Application Reference: Y/9/25/DOC	Initial Issue Date: 21/02/2025
Site Name: Fleurie Nursery Lake Lane Barnham PO22 0AL	Issue Date:
	Reviewer Reference: ADC/SB

Application Reference:	Y/9/25/DOC	Reviewer Reference:	ADC/SB
Planning Officer:	Amber Willard	Date of Review:	21/02/2025
Site Name:	Fleurie Nursery Lake Lane Barnham PO22 0AL		
Application Description:	Approval of details reserved by condition imposed under reference Y/26/24/PL relating to condition number 4 - surface water drainage scheme, condition number 5 - discharge flows to watercourses, condition number 6 - maintenance and management of the surface water drainage system and condition number 10 - Biodiversity Enhancement Layout.		
Assessment Number:	1 of 2

- Cover Letter Ref C2904 dated 17 December 2024
- C2904-P-201 Rev P1 – Proposed Contributing Area
- C2904-P-101 Rev P3 – Proposed Drainage Strategy
- C2904-P-501 Rev P1 – Proposed Typical Construction Details
- C2904-P-601 Rev P1 – OWC Application Sheet 1
- C2904-P-602 Rev P1 – OWC Application Sheet 2
- Storm Network KCK Attenuation_11.pfd [Fleurie, Lake Lane] dated 12.12.2024

# PRELIMINARY

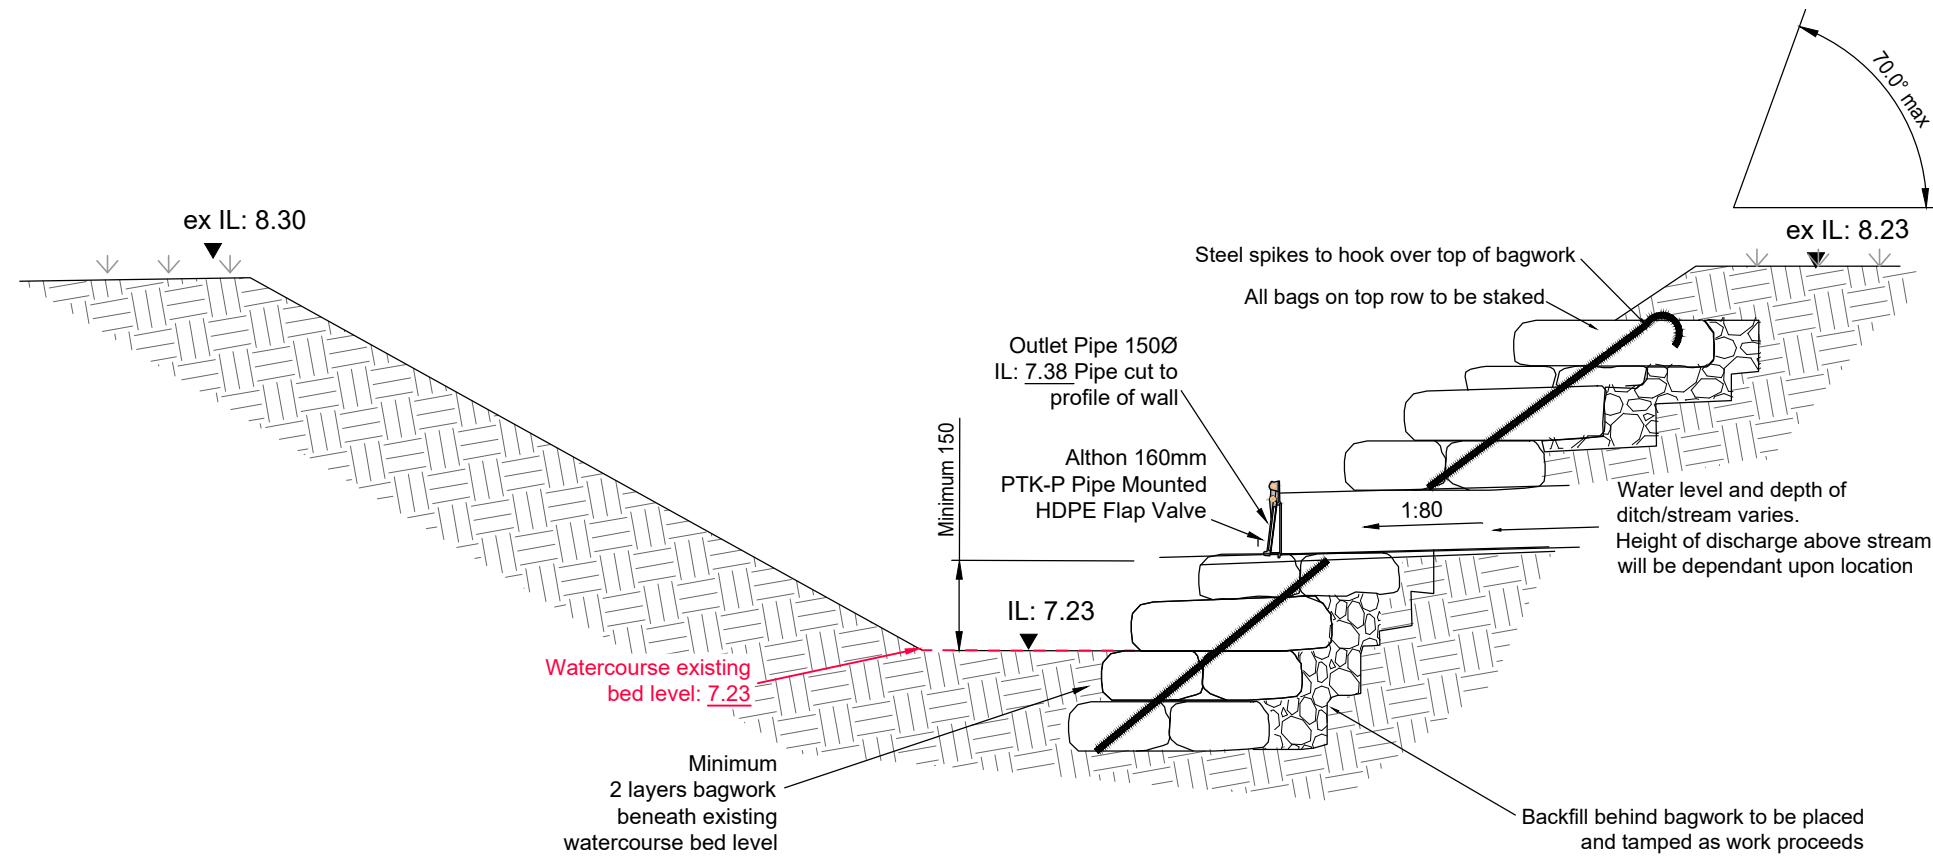
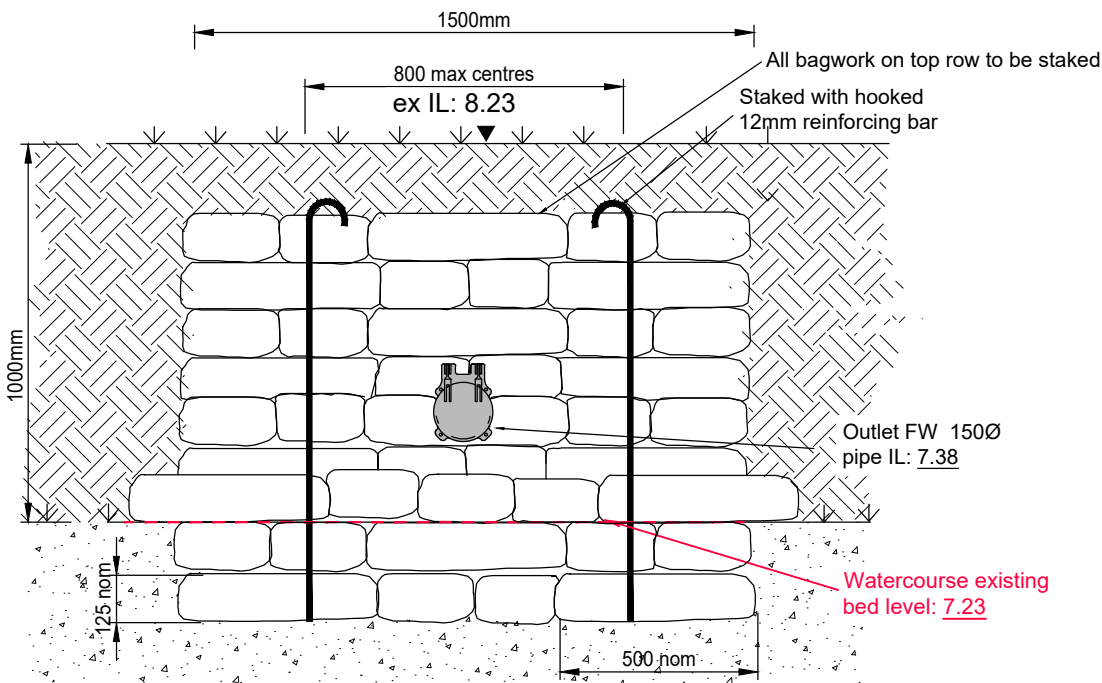
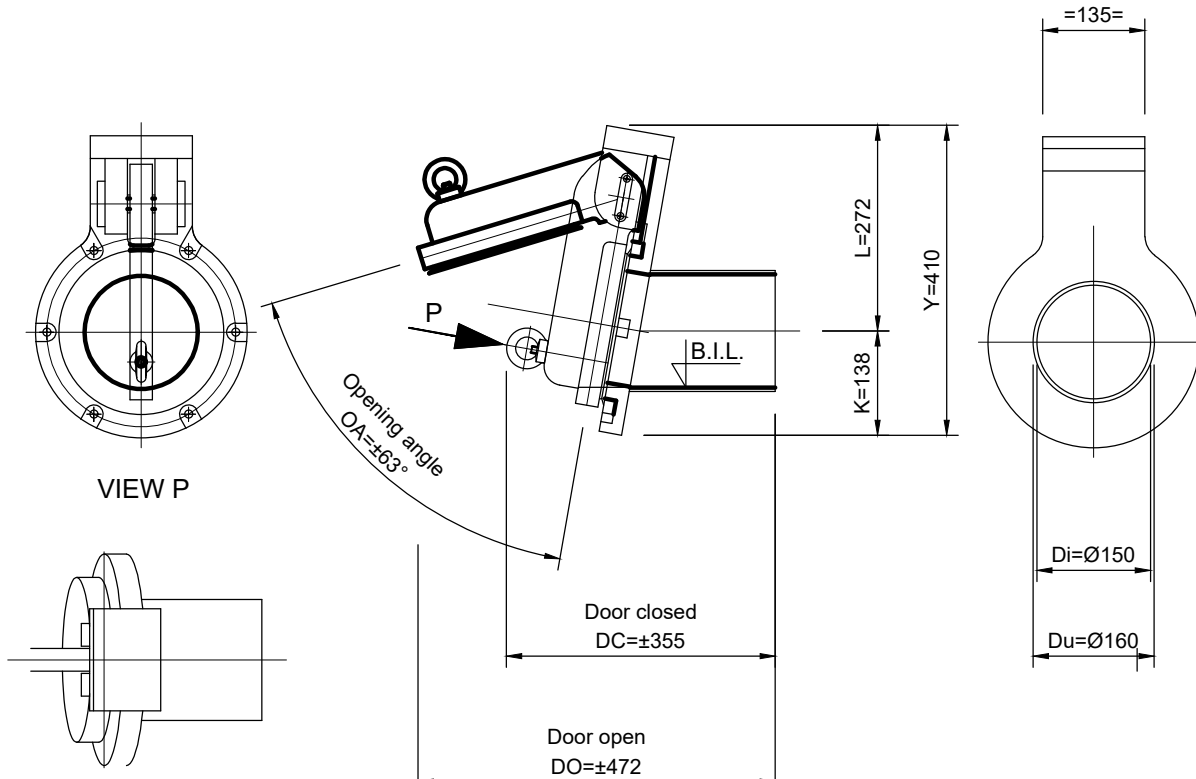
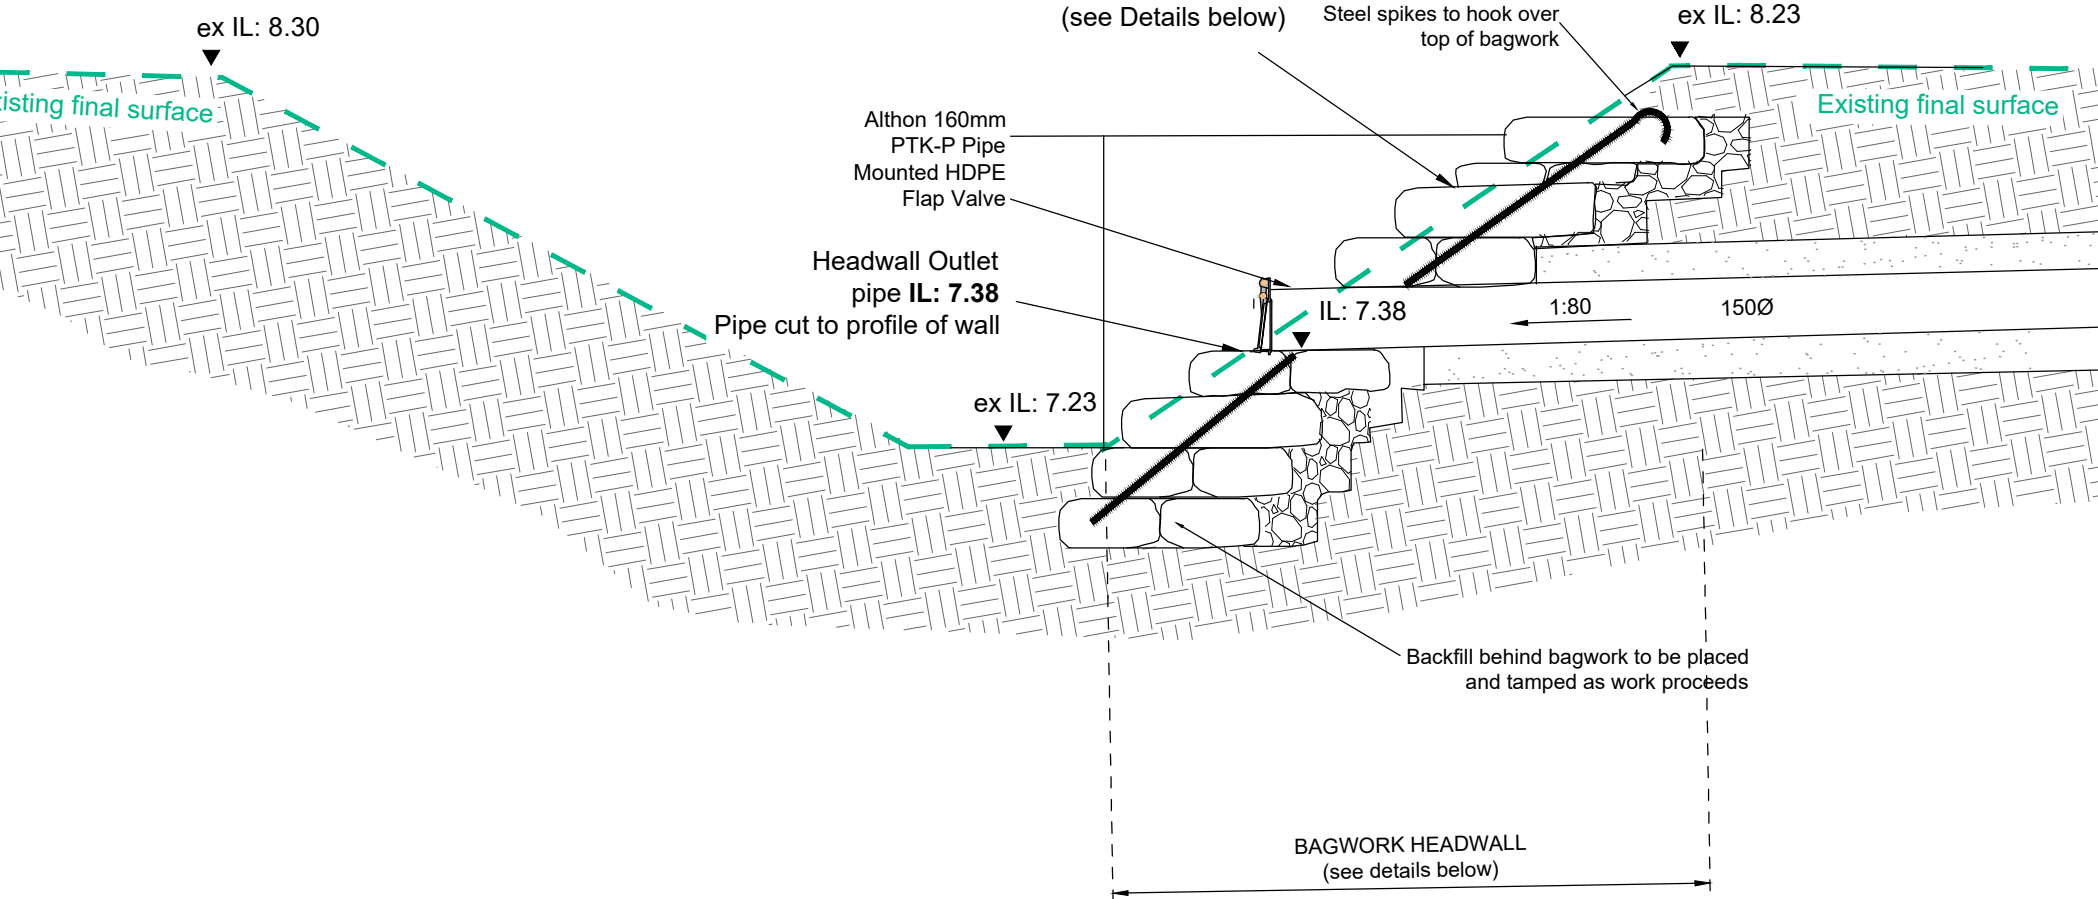
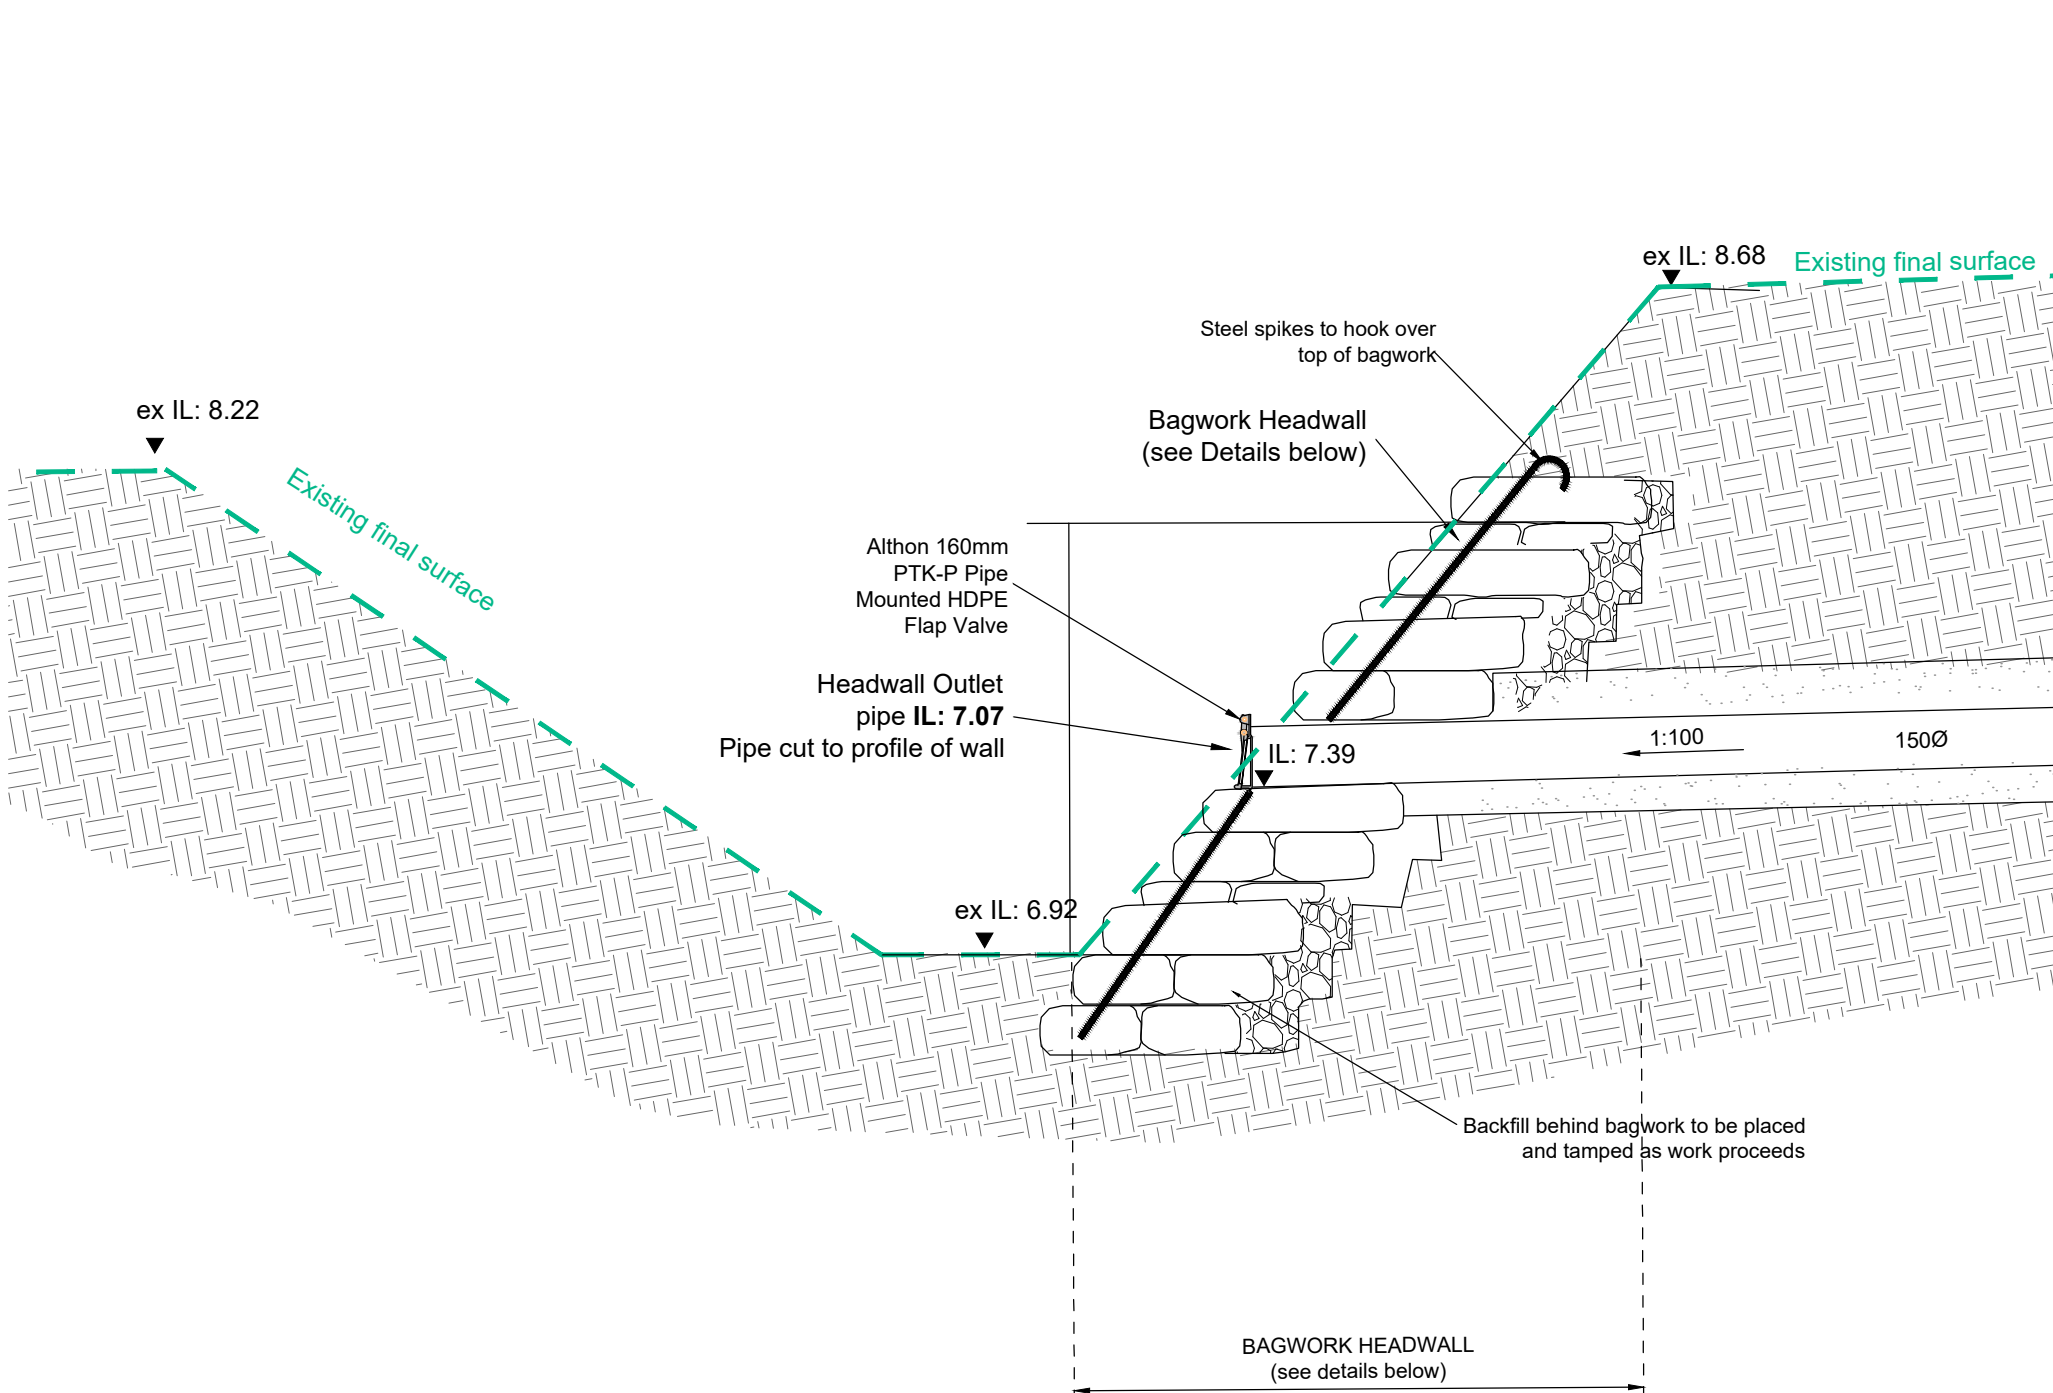
12.	The modelling does not include the flap valve.				
13.	Please remove the standard (non-site specific) headwall details from C2904-P-501. These contradict the OWC drawings which are more detailed and site specific.
